Stonestreet Green Solar

Statement of Common Ground with the Environment Agency

PINS Ref: EN010135

Doc Ref. 8.3.2(A)

- Notes:**
- All hedgerow reinforcement planting to be done within the DCO boundary.
- Legend:**
- ORDER LIMITS
 - EXISTING SURVEYED TREES AND VEGETATION
 - EXISTING WATERCOURSES AND FEATURES

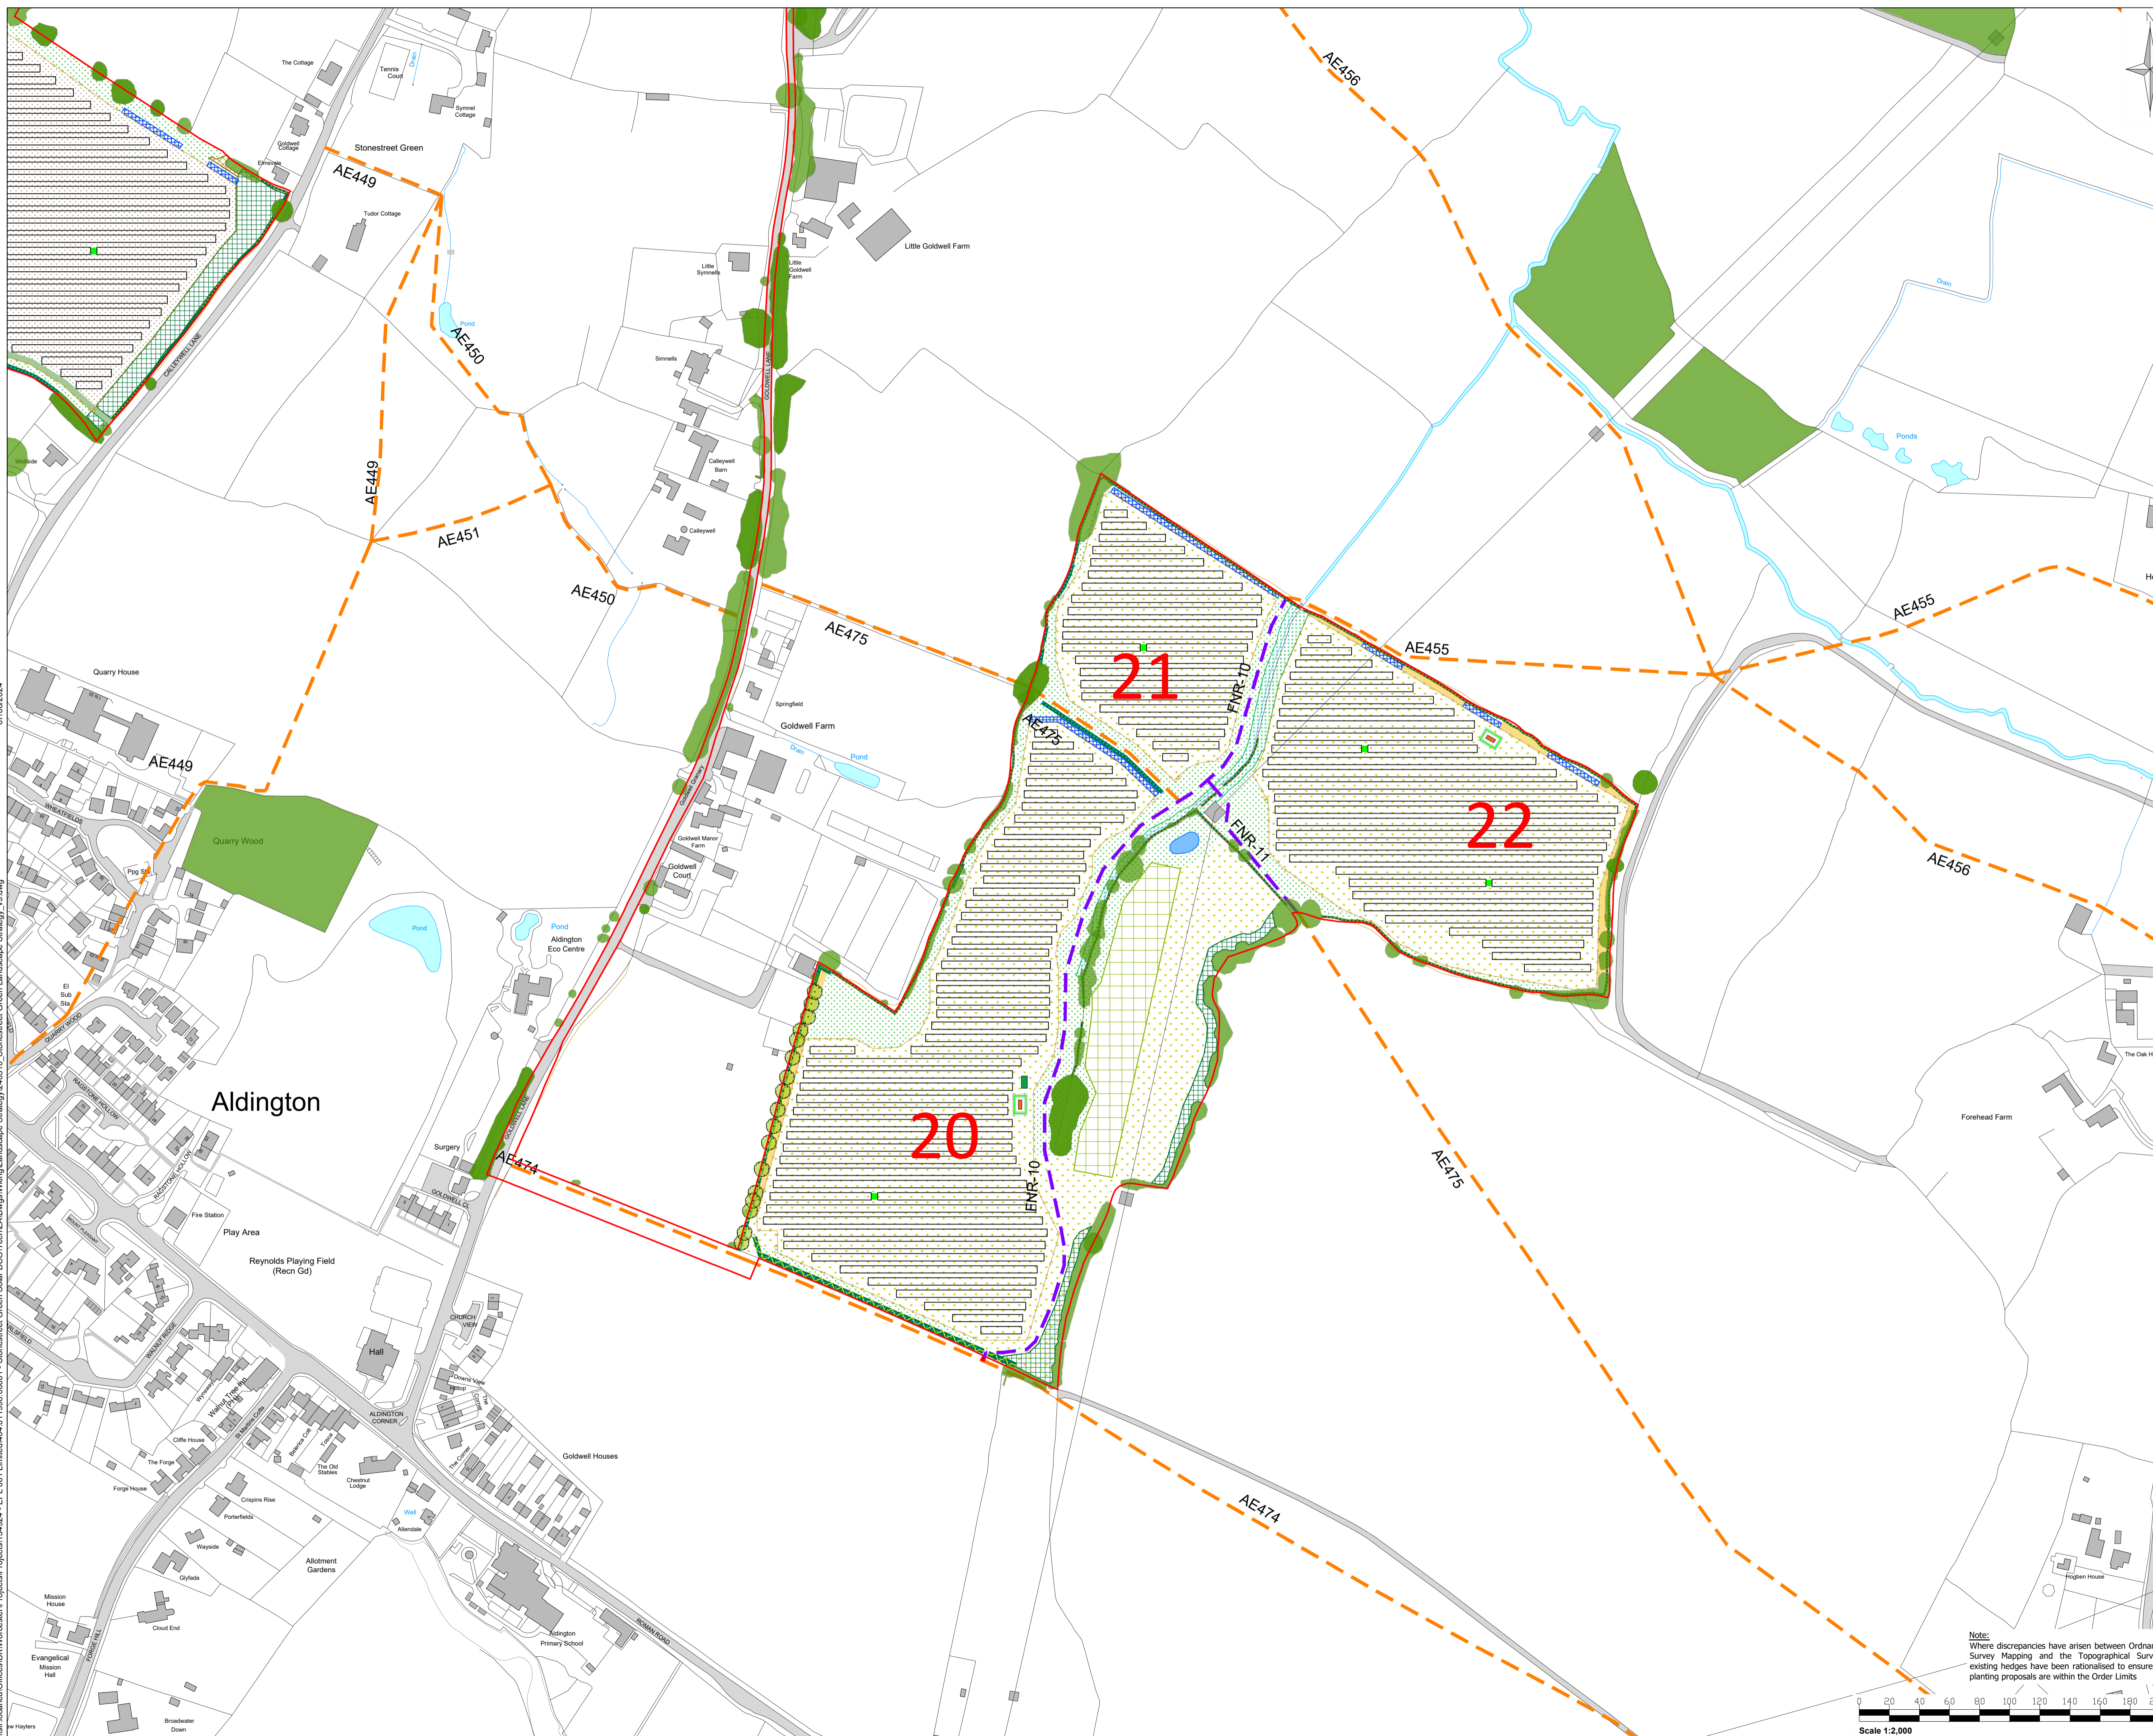
2.10 to 12	RR	Issue 3 - Flood Storage Calculations	<p>Situation: The 'Floodplain Compensation level for Level Calculation' table from 'Annex D: Floodplain Compensation Level for Level Calculations' of the FRA demonstrates a net increase (1,543.11 m3) in flood storage downstream of the Aldington Flood Storage Area but does not show any net increase within Aldington Flood Storage Area as referenced in the Outline Operational Surface Water Drainage Strategy (OOSWDS). Paragraph 5.1.5 of the OOSWDS states "The swale and wetland areas have both been designed to enhance biodiversity and ensure that there is no adverse impact on water quality. In addition, the wetland area, which will be sited within the AFSA, will increase the capacity of fluvial flood storage available. This will therefore contribute to a small reduction in downstream flood risk." (<i>APP-094 – Doc 5.4 Environmental Assessment</i>)</p>	<p>None of the works proposed within the AFSA involve any build up in ground levels.</p> <p>The works proposed relate to;</p> <ol style="list-style-type: none"> 1. Superficial treatments and vegetation management with a commitment made that vegetation management will be ongoing with any accumulated material removed from the AFSA. Such work would therefore have a neutral impact on flood storage, 2. The provision of fencing around the skylark area in Field 29 as illustrated on the Illustrative Landscape Drawings (Doc Ref. 2.7(A)) [REP1-005] (Sheet 3 of 5 - drawing number 011998.00001.712). The fence posts would result in a negligible loss of flood storage, but at a level that would be difficult to quantify. 3. The creation of ecological scrapes and ponds as illustrated on the 	Under discussion

2.13	RR	Issue 3 - Flood Storage Calculations	<p>Solution: The applicant should also confirm that there is no loss of flood storage capacity in Aldington Flood Storage Area from the landscaping works including but limited to the woodland planting, tree planning, habitat scrapes and habitat ponds.</p> <p>22/11/2024 (EA) No further comments, our above comments for Issue 2.10 to 12 apply.</p>	As above	Under discussion

Ref	Relevant Application Document	Description of Matter	EA Current Position	Applicant's Current Position	Status
			<p><i>Appendix 10.2: Flood Risk Assessment; APP-159 – Doc 7.14 Outline Operational Surface Water Drainage Strategy</i></p> <p>Impact: The storage capacity of Aldington Flood Storage Area may be reduced by the proposed landscaping works.</p> <p>Solution: The applicant should amend the flood storage calculations within the 'Floodplain Compensation level for Level Calculation' table from 'Annex D: Floodplain Compensation Level for Level Calculations' of the FRA to show the flood storage increase inside Aldington Flood Storage Area as stated in the paragraph 5.1.5 of the OOSWDS "increase the capacity of fluvial flood storage available".</p> <p>22/11/2024 (EA) As outlined above when the Outline OSWDS (Doc Ref. 7.14) is updated to include that there will be no net loss of storage capacity within the AFSA this will be conditioned. We have no further comments to make until we have reviewed the requested supporting calculations and updates to</p>	<p>Illustrative Landscape Drawings (Doc Ref. 2.7(A)) [REP1-005] (Sheet 3 of 5 - drawing number 011998.00001.712). These would be formed by excavation only with all spoil removed disposed of outside of the AFSA. As such these works would only increase the available flood storage volume.</p> <p>4. The creation of the wetland area which will receive storm runoff from the Project Substation. This will be formed by excavation and will not involve impounding water to a level above the existing ground surfaces. As such the formation of this feature can only increase the volume of flood storage available.</p> <p>The net effect of these works will clearly be an increase in the available flood storage volume within the AFSA. On this basis no further assessment was deemed necessary.</p> <p>In response to this comment work is however now being undertaken to quantify the changes resulting from items 2, 3 and 4 above. This additional detail will be included within ES Appendix 10.2: Flood Risk</p>
